Recommendation Report for Planning Permission for Works or Extension to a Dwelling

REF NO: BN/122/21/HH

LOCATION: 44 Spinney Walk
Barnham
PO22 0HT

PROPOSAL: Erection of single storey rear and front porch extension

TITLE:-		Rear Extension, Porch and internal works @ 44 Spinney Walk Barnham West Sussex PO22 0HT
DATE:-	30th August 2021	
SCALE:-	Floor & Roof Plans Scale 1-100 on A2 Paper	
DRAWN:-	P.Robinson	
DWG. No. 2021077/PL/1

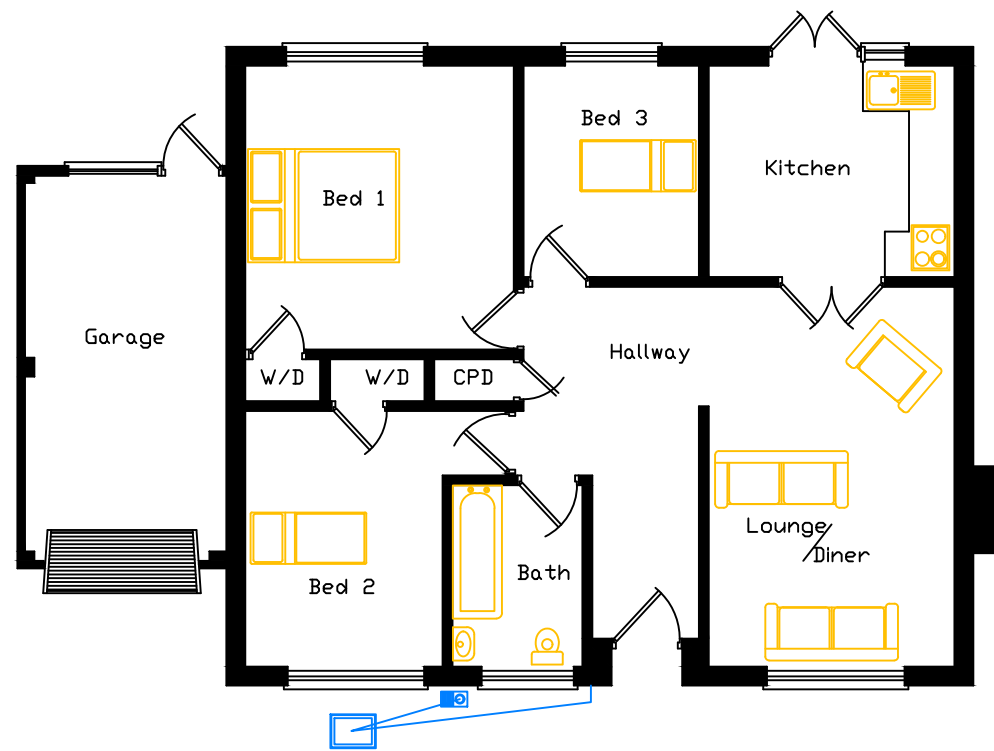
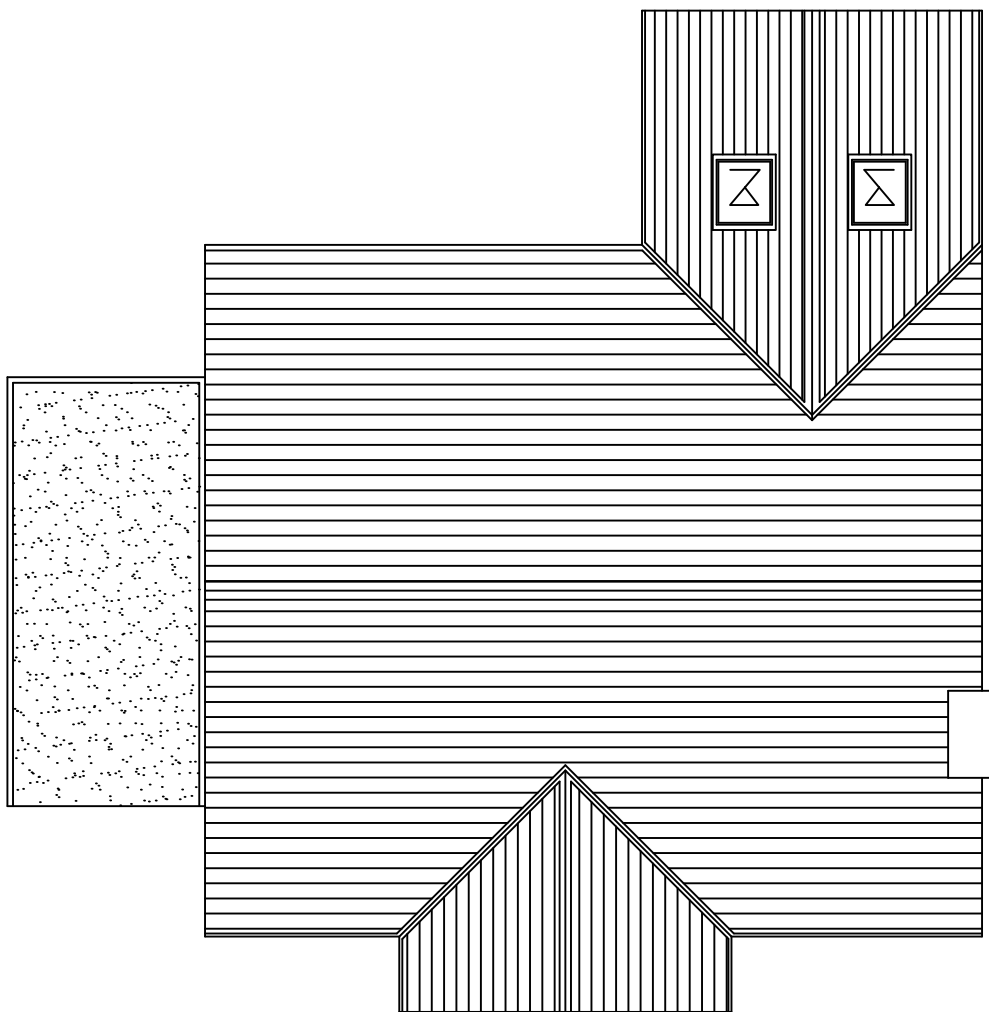
The front extension is to the center of the dwelling with a depth of 1.25m. It will have a pitched roof with eaves to match the host dwelling, with a maximum height of 3.6m. The design adds some bulk to the front however it appears well integrated and a subservient addition.

To the rear the extension will have a depth of 3.3m. It will have eaves to a height of 2.4m which join with the host dwelling and a pitched roof height of 4.4m. This has a width of 4m. This is approximately 1m from the southern boundary and retains 7.5m to the northern side.

There will be a window which faces east and being single storey provides views of the garden of the host dwelling. There will be a door to the north and with sufficient separation retained to the boundary at 7.5m

DWG. No. 2021077/PL/1A

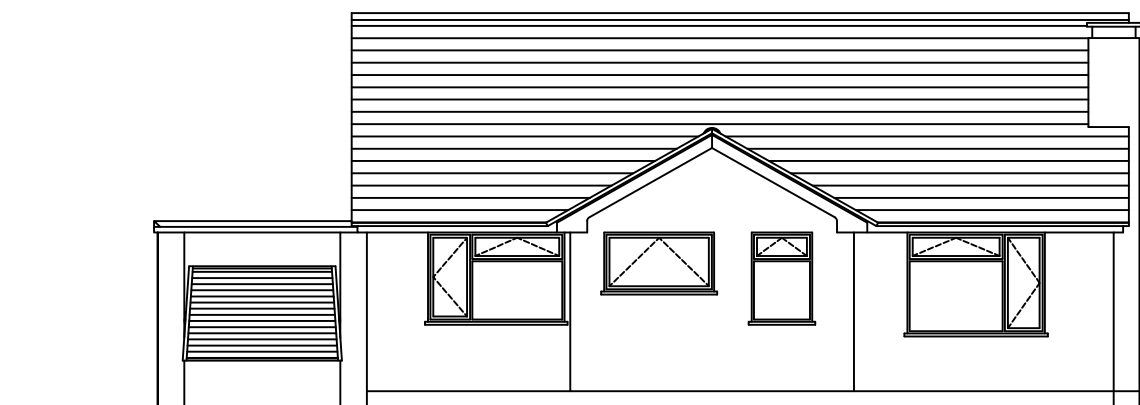
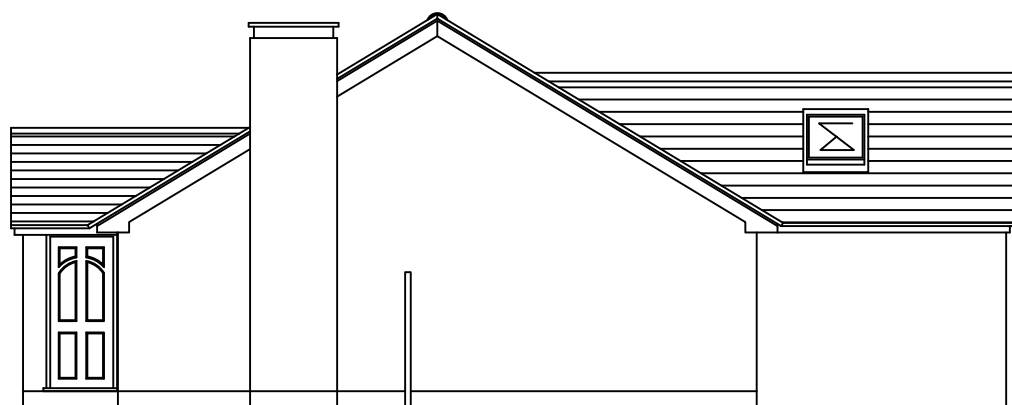
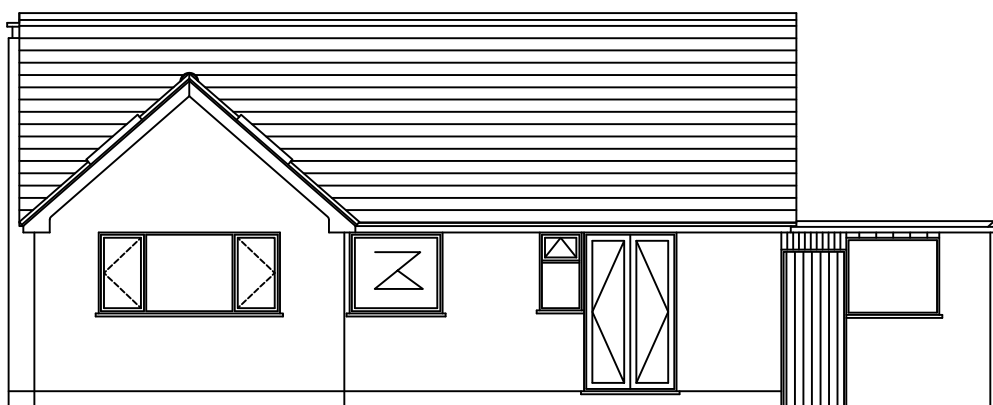
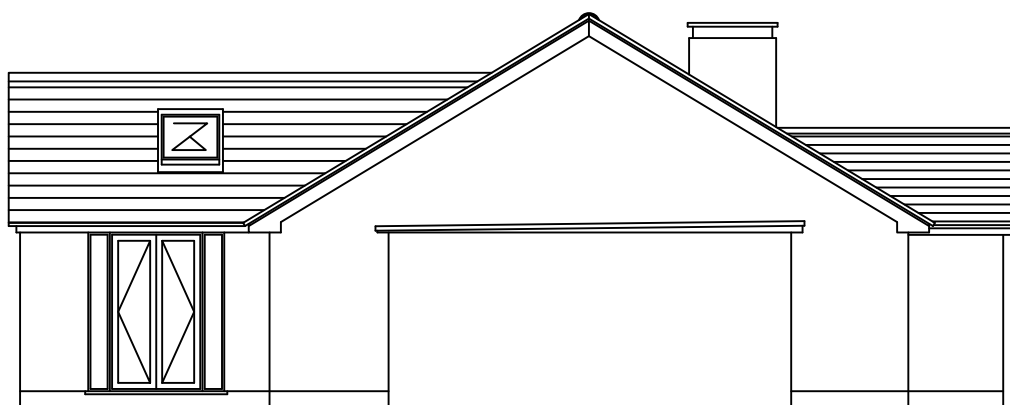
The rear extension is similar in design although not visible from the street scene.
